From: [REDACTED]
Sent: 14 December 2020 10:43
To: Amber Willard
Subject: RE: P/108/20/HH
Attachments: P0010 - Section.pdf

P/108/20/HH

A	Section created	14 Dec 2020
Rev	Revision	Date
PROJECT		
32 East Front Road, Pagham		
TITLE		
Section		
DRAWING No.	SCALE (@A1)	Project Ref:
P0010	1 : 25	J20025
THE EMARRA COMPANY		
www.emarra.co.uk Tel: 07803 924465 Email: info@emarra.co.uk

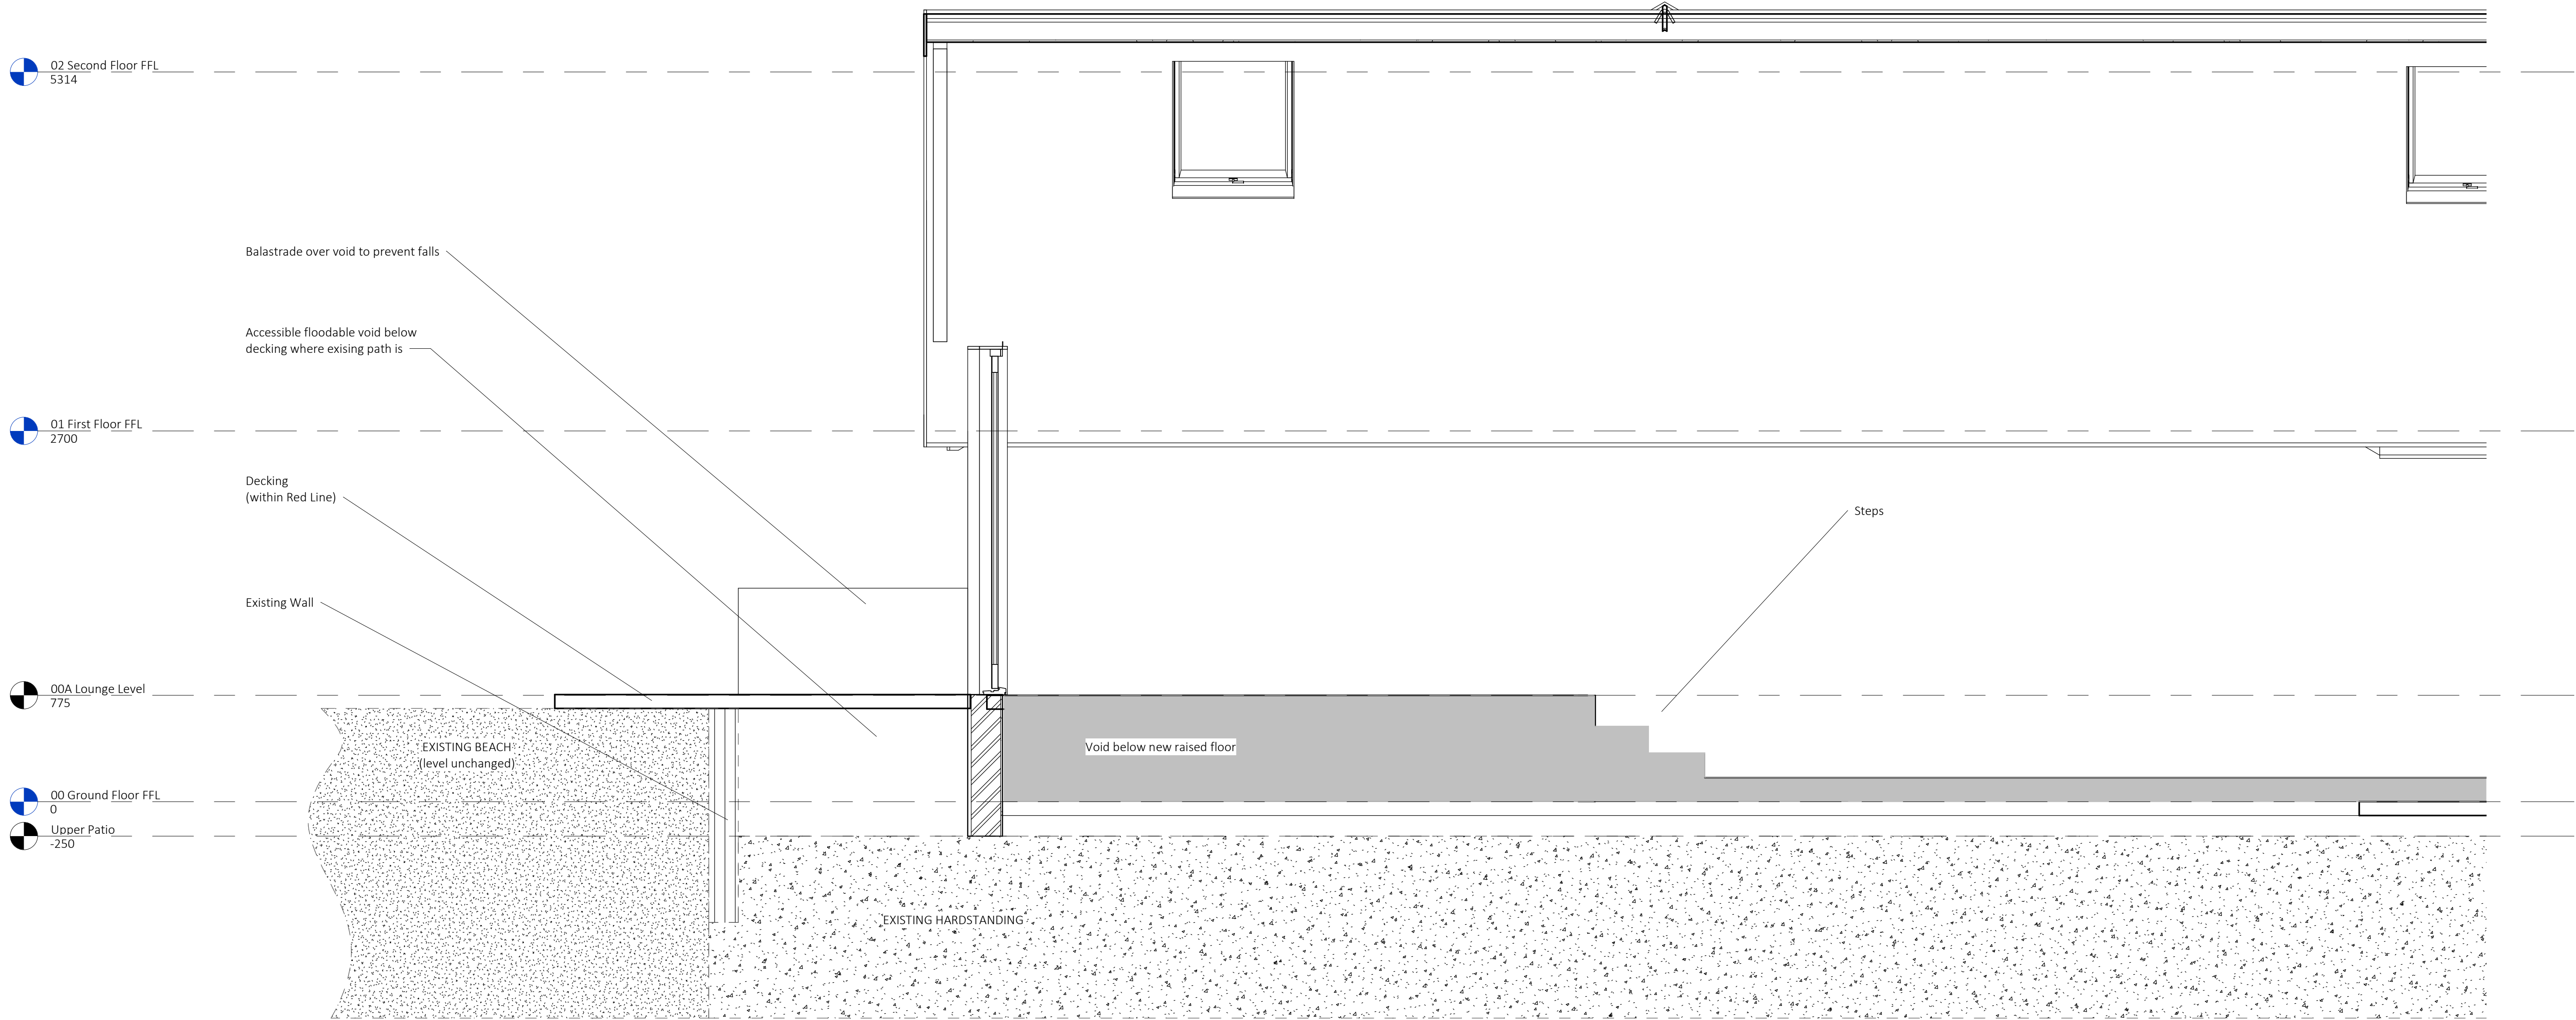
I note it states the rear living room area floor level will be raised, so the doors open out onto the decking. Can you advise how high the decking will be off the floor as it is hard to tell from the plans.

If you could provide a section plan to demonstrate the floor level from the rear and the decking height etc, this might help.

I'm am just trying to figure out whether the height will give rise to any views to the neighbouring sides and how this will look when viewed from the south.

The beach is about 1m above the current external level (about 775mm above the current floor level). We propose to bring the internal floor level up to this height just in the lounge area by creating a raised platform internally with some steps up internally. The decking will be fixed to the house, and the wall. It will then oversail the beach, basically cantilevered at beach level, all within the red line as defined on the title deeds.

Please see attached.

Because this is at beach level, it is no different to standing on the beach. It is not raised in any way. Below is an approximation of how it will look from the south:
